ENG-PUDSP20005-R1-TIS-redlines.pdf Markup Summary

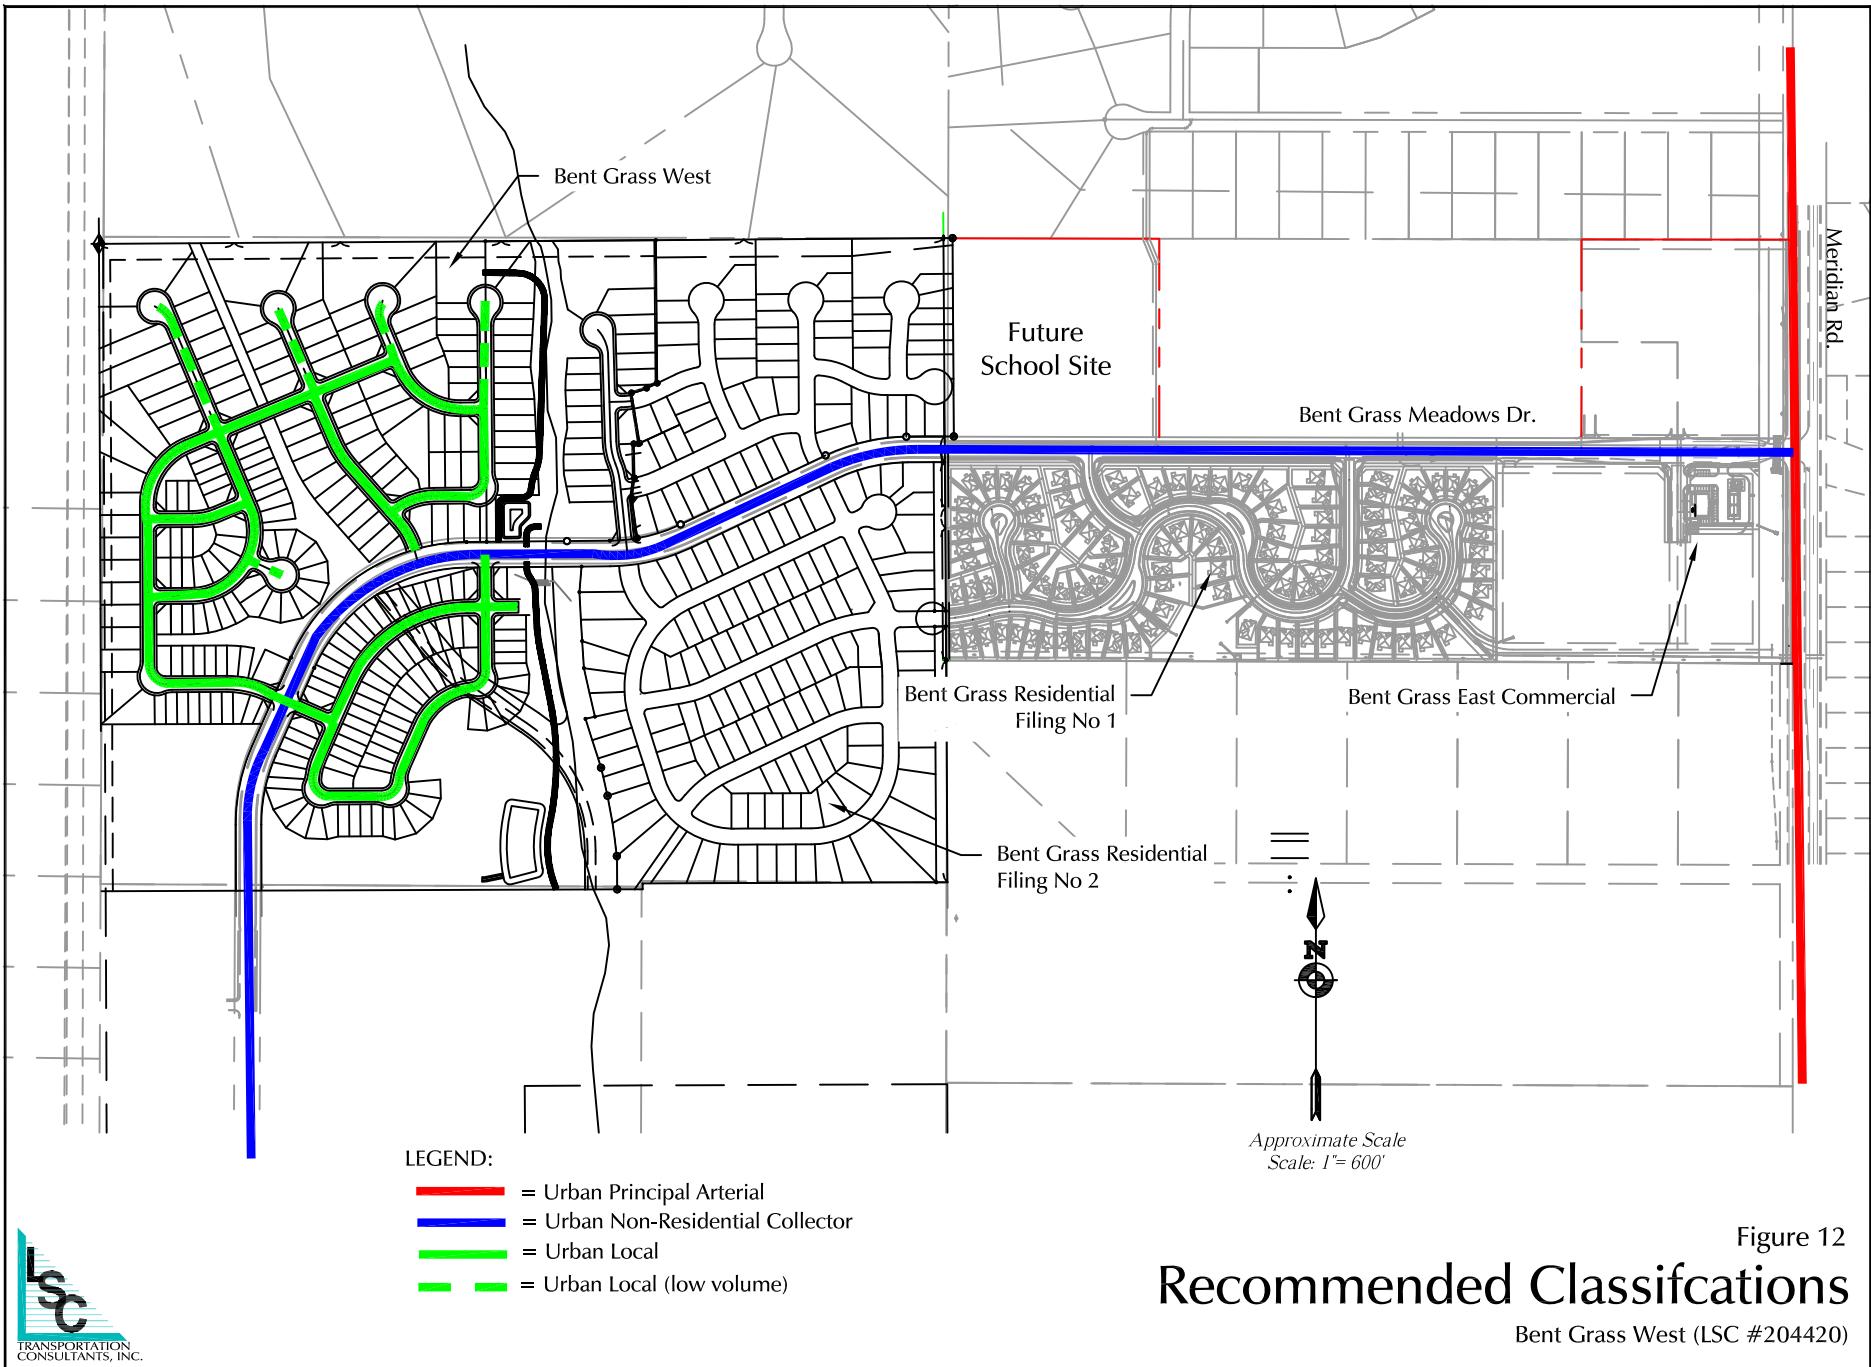
Label road names - Lemon Grass, Berwyn, Lynch, Kittrick, Rowena, Hanzlee, Sea Oats, Avena...
